Office of
Environment
& Heritage

DOC18/407557
SSI 8256

Preferred Infrastructure Report - Sydney Metro Sydenham to Bankstown - SSI 8256

Attachment 1 – Office of Environment and Heritage (OEH) comments Sydney Metro Sydenham to Bankstown - SSI 8256 - Preferred Infrastructure Report

Figure 15: Punchbowl Station survey unit and S2B PAD02

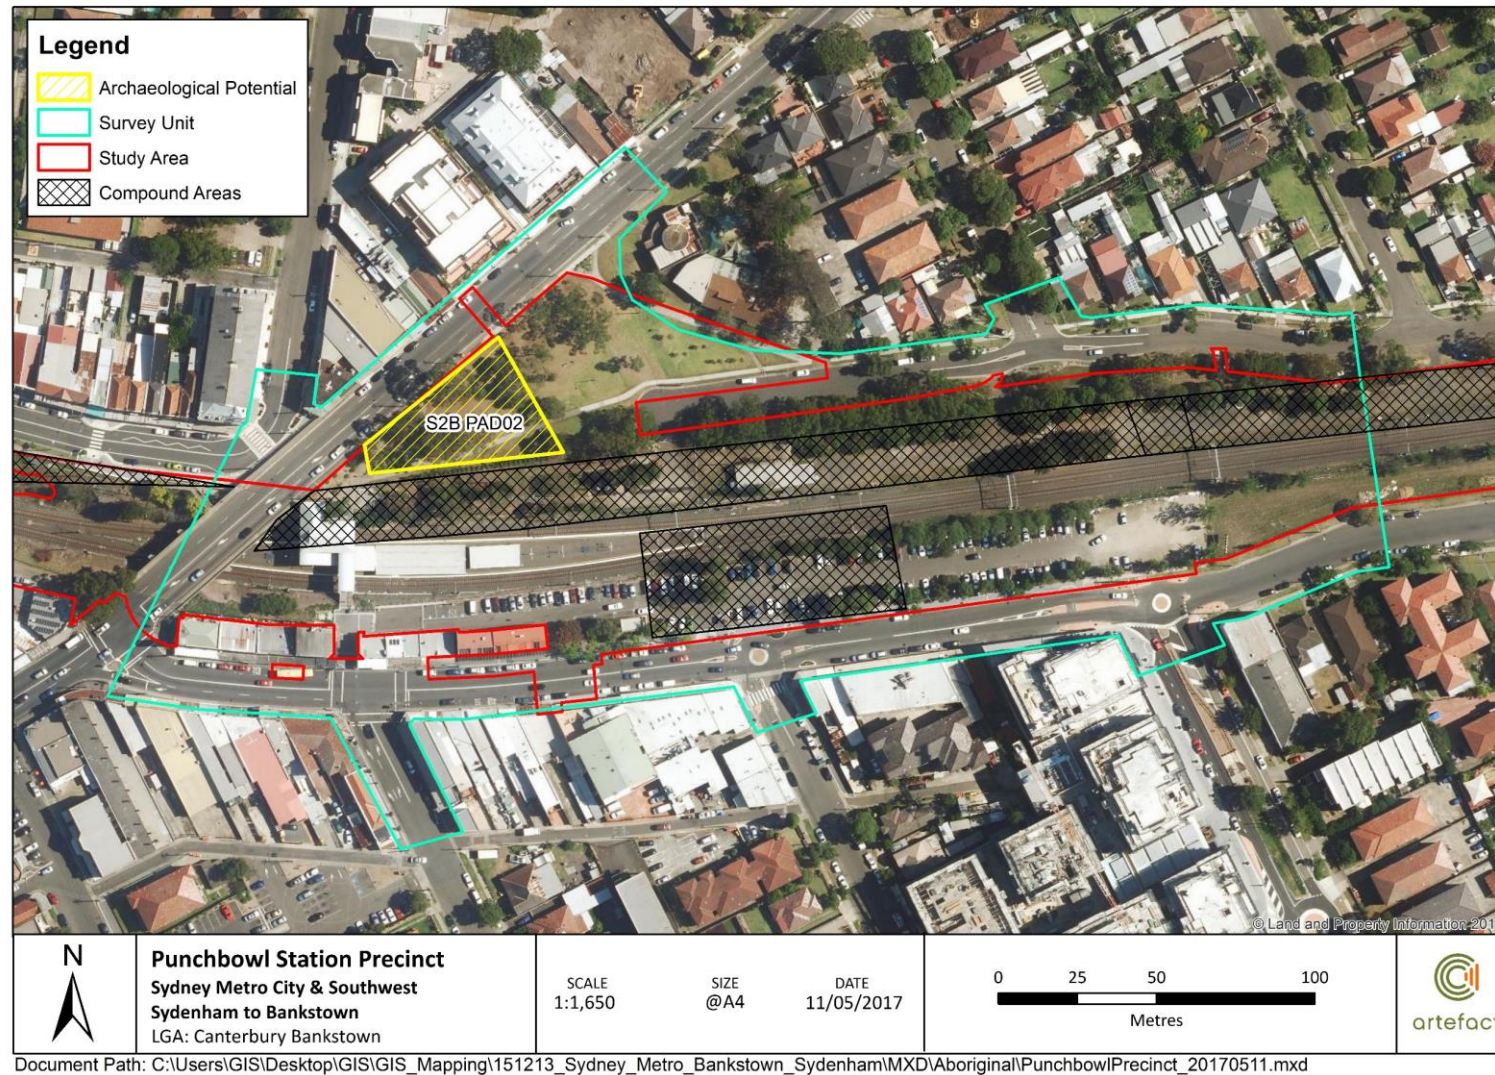
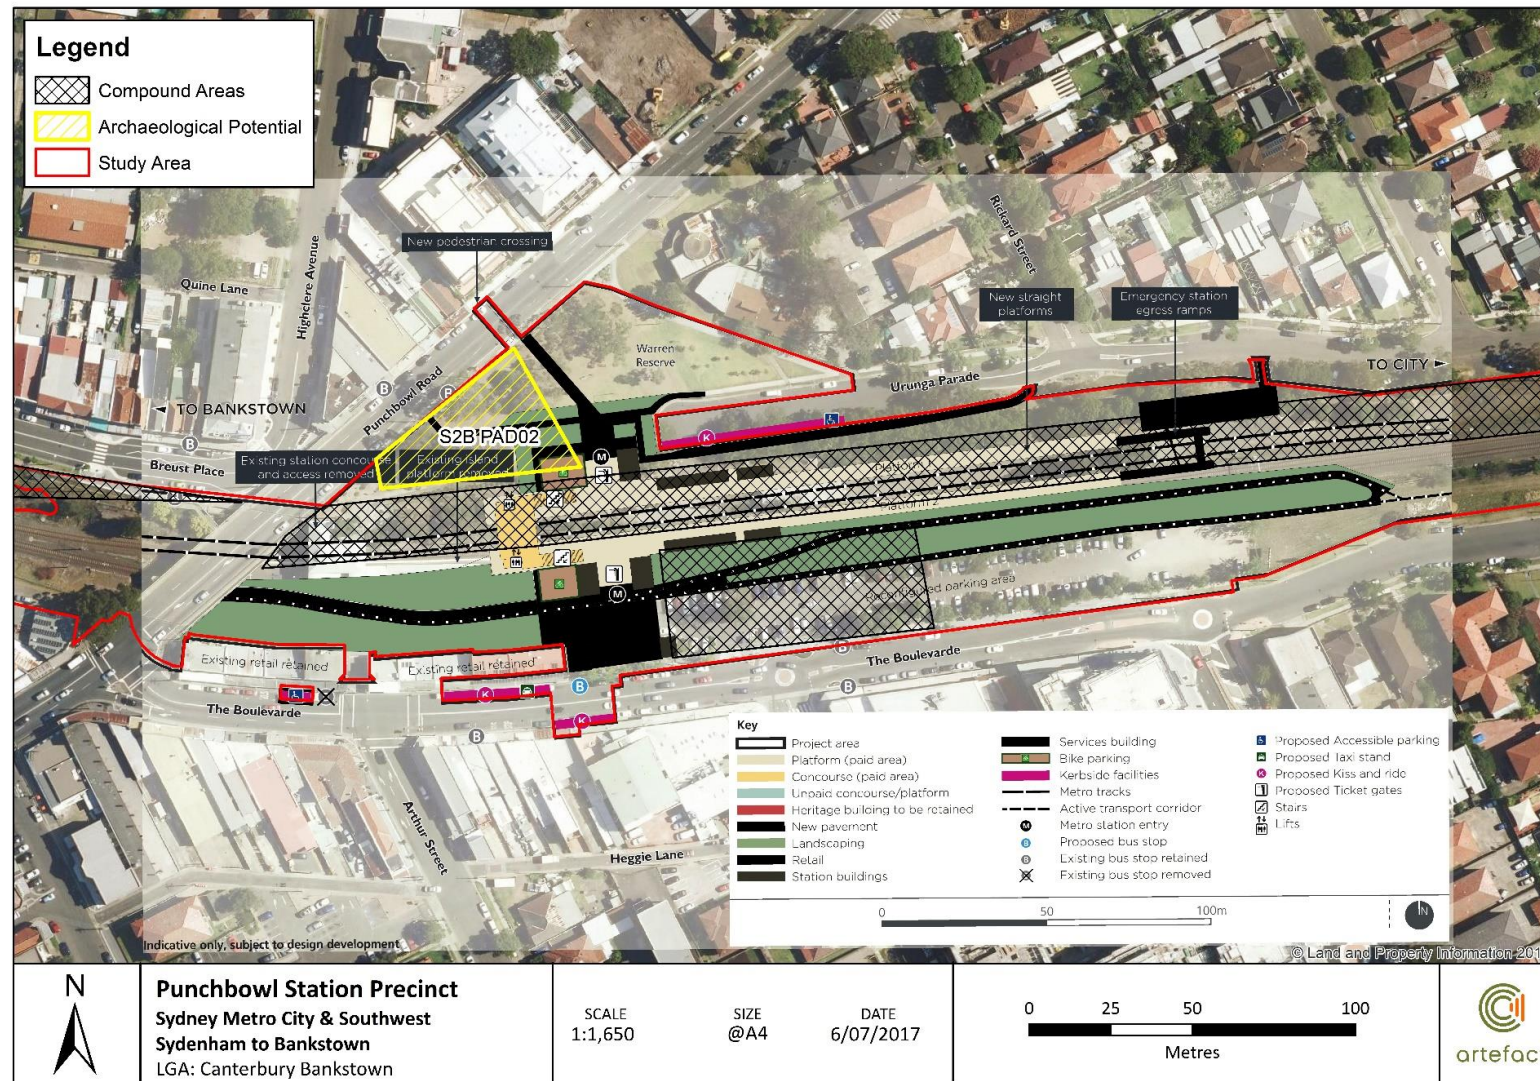
The construction of the project may disturb a potential Aboriginal archaeological deposit of moderate significance that has been identified as having low to moderate potential for intact archaeological deposits known as S2B PAD 02 located adjacent to Punchbowl Station. Given this and the need to minimise the potential impacts of the project on Aboriginal heritage, the following mitigation measures and conditions should be imposed on the project approval:-

- Archaeological Method Statement for excavation at S2B PAD02.
- Implement mitigation measure AH3:
 - minimise potential impacts on S2B PAD02 and, if impacts cannot be avoided, undertake archaeological test excavation (and salvage when required) in accordance with the Aboriginal Cultural Heritage Assessment Report.
